From: Bloomer, David <David.Bloomer@lancashire.gov.uk>
Sent: 21 April 2017 10:16
To: Robert Major
Cc: LHS Customer Service; planning
Subject: app3/2017/0294 and 0295 Former Punch Bowl . Longridge Road

Previous Highway comments app 2016/ 0056 & 57

EXISTING SITE PLAN
SCALE 1:500 @ A3

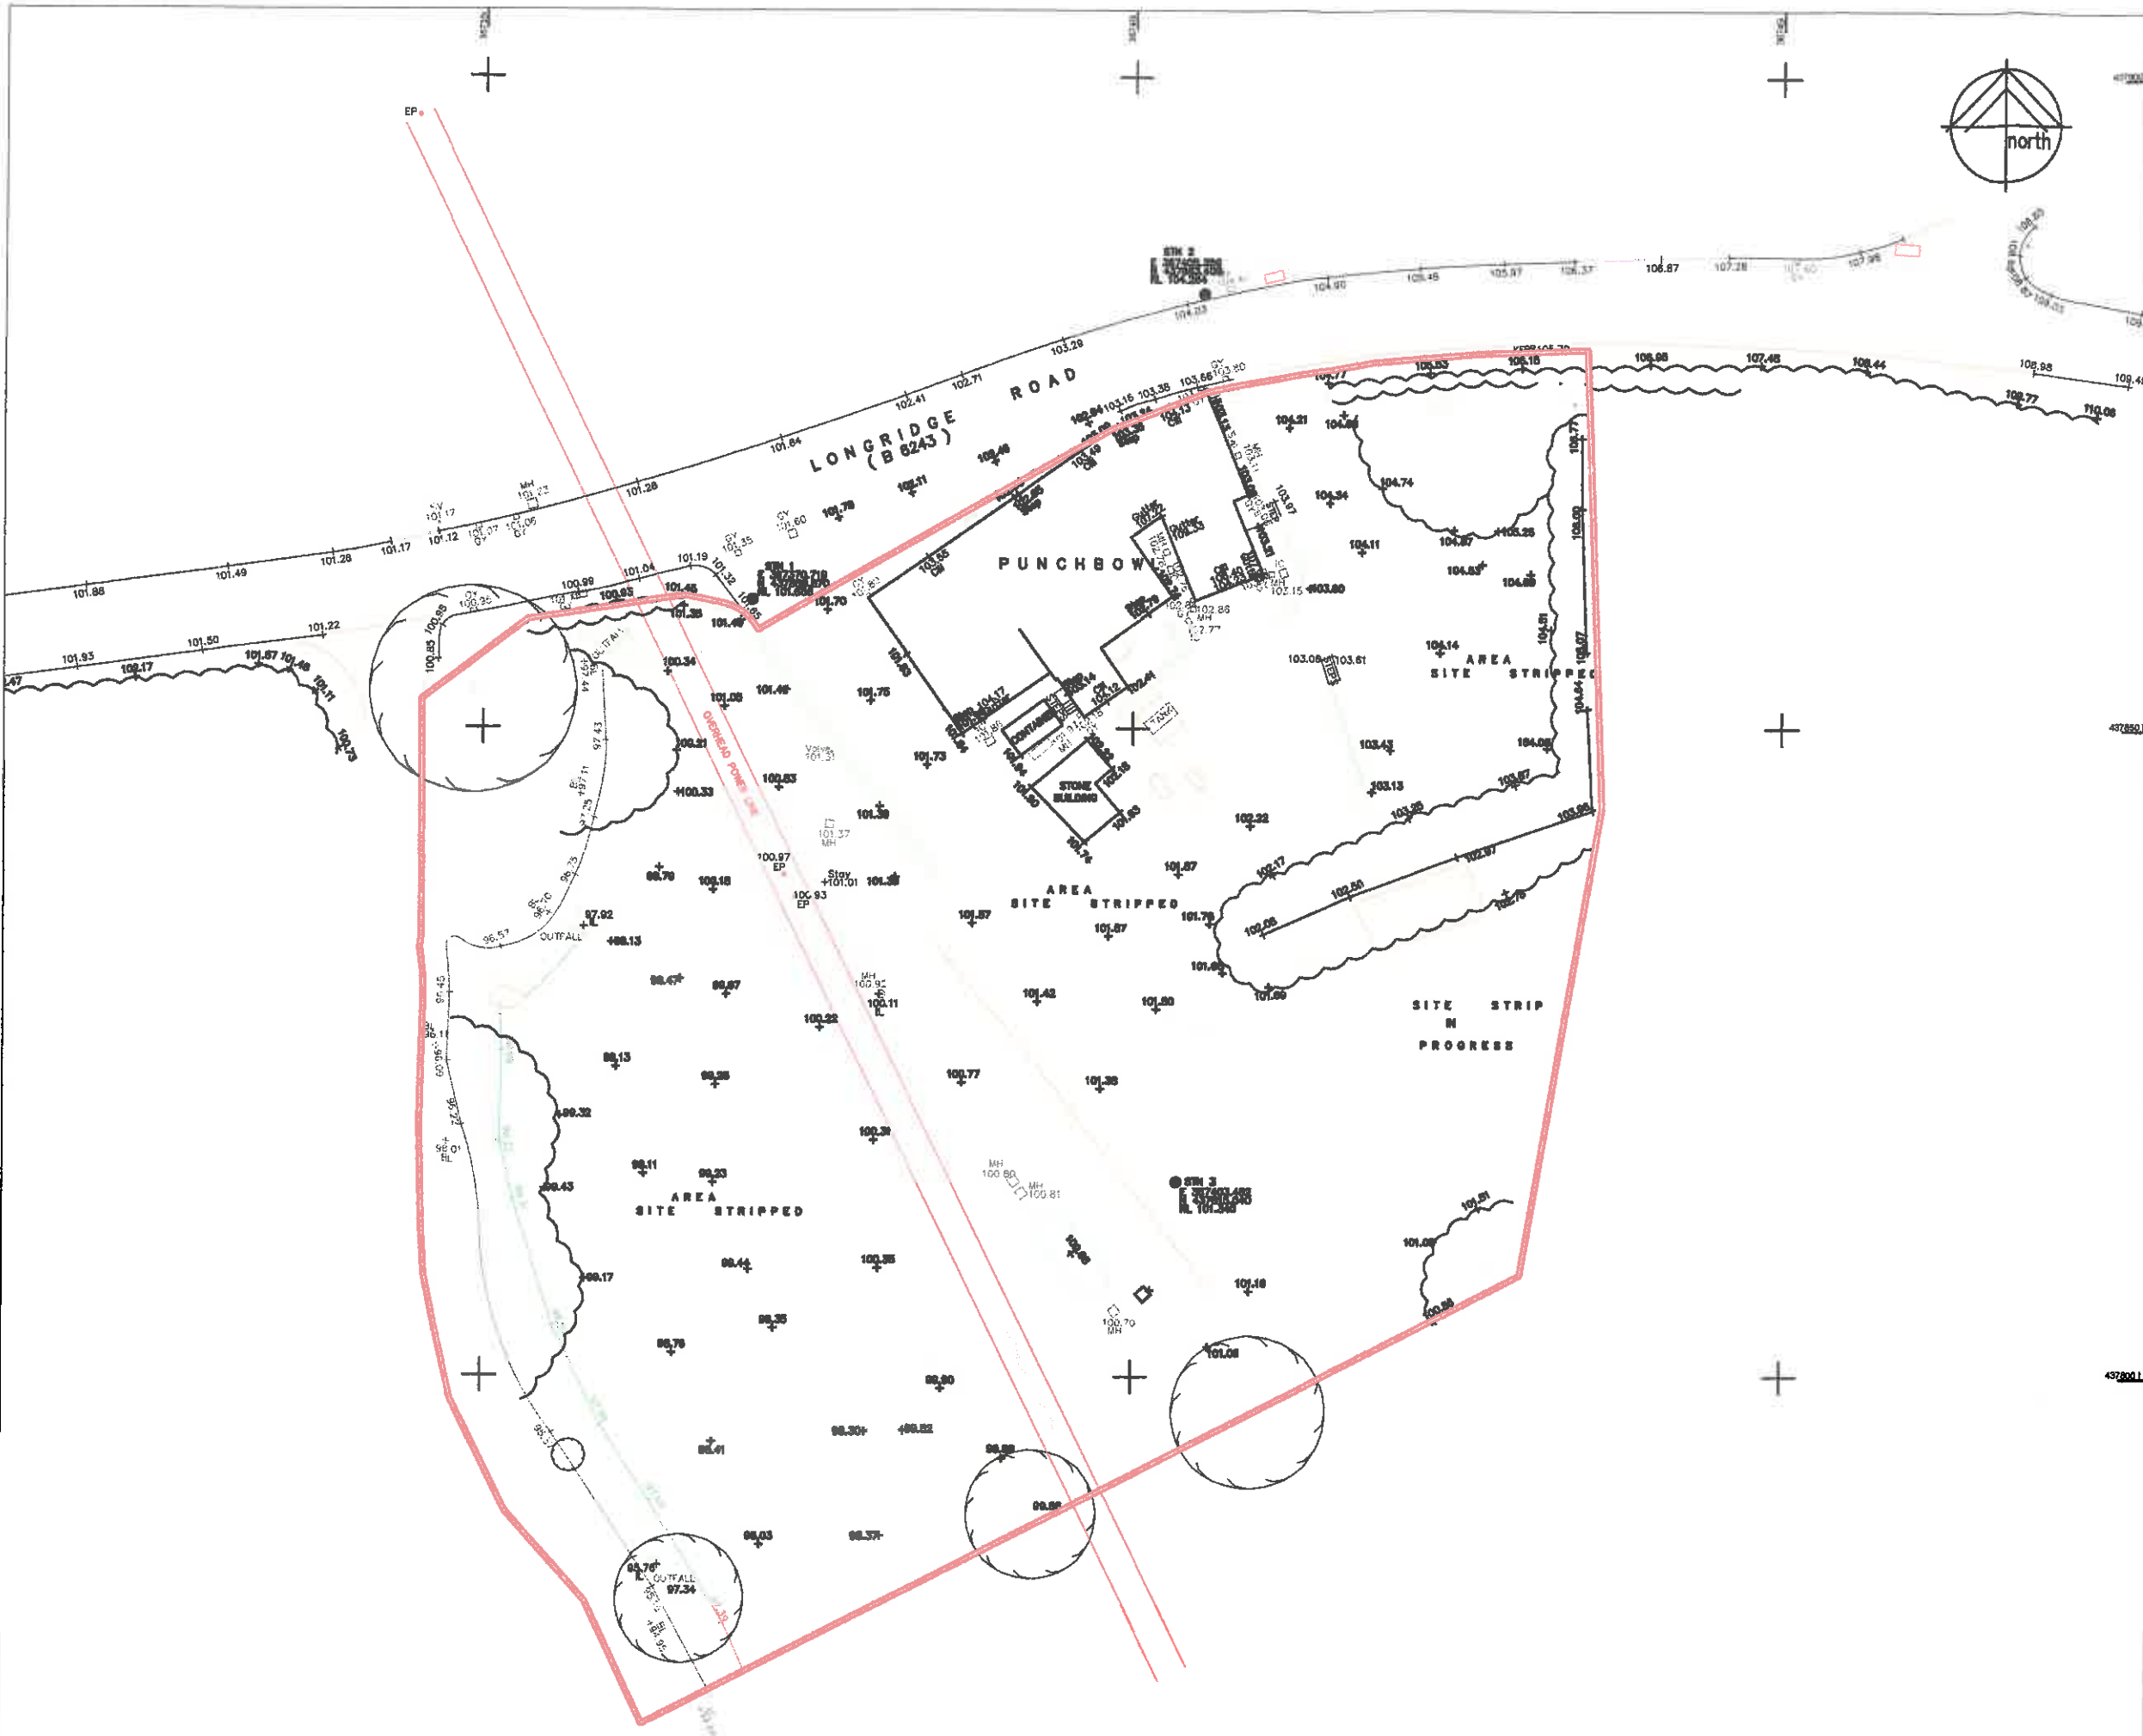
In terms of the site as a whole I would have to reiterate my concerns regarding the visibility available at the site access which would still elicit a recommendation for refusal on highway safety grounds. In respect of the number of parking spaces offered for the holiday lets and café, the reduction in the number of caravans proposed has allowed an increase in the number of parking spaces for these uses from 12 to 17. This remains less than the 19 – 22 as suggested in my previous response below. On the basis of this I still have highway concerns regarding the safe operation of this site and would therefore reiterate my position that the proposal should be refused on highway safety grounds resulting from the poor site lines at the site entrance and the inadequate parking provision.

Using the DB32 32 formula for the calculation of the Stopping Sight Distance (SSD) the required visibility is 116metres. Using the MfS formula the calculated SSD using vehicle speeds of 44mph and not the speed limit figure of 40mph. is 43metres. On the basis of this I would consider that the visibility for vehicles emerging from the car park is inadequate and would elicit a recommendation for refusal of the proposal as submitted on highway safety grounds. I am aware that there is a traffic mirror opposite the site entrance which offers some improvement but its usefulness would be dependent on the prevailing weather conditions and not everyone would be comfortable in interpreting the information when deciding when I is safe to emerge.

Turning to the car parking provision, the car parking provided for the former pub development element (café and 5 holiday units) is 12 spaces. I would consider this to be insufficient for the scale of the development . On the basis of 1 parking space being provided for each of the holiday units (5 spaces) and a further 17 spaces for each table in the café the total parking provision should be in the region of 22 spaces. Using the County Parking Standards this equate to 14 spaces for the café based on the gross floor area,

and a further 5 for the holiday units. . Due to the remote location of the site it is inevitable that the majority of customers will arrive by car and it is essential that all the parking generated by the site is contained within curtilage as any overflow parking on Longridge Road would present a highway safety issue. The current parking provision on site is in the region of 28 vehicles.

Whilst I accept that the former pub use would have generated some trips to the site , the addition of the 20 holiday chalets, whilst increasing the visits to and from the site also reduce the availability of on sit parking for the uses proposed for the existing building, on this basis I would have to recommend that the application be refused on highway grounds due to the impact of this additional development on the inadequate sight lines and the lack of an appropriate parking provision.
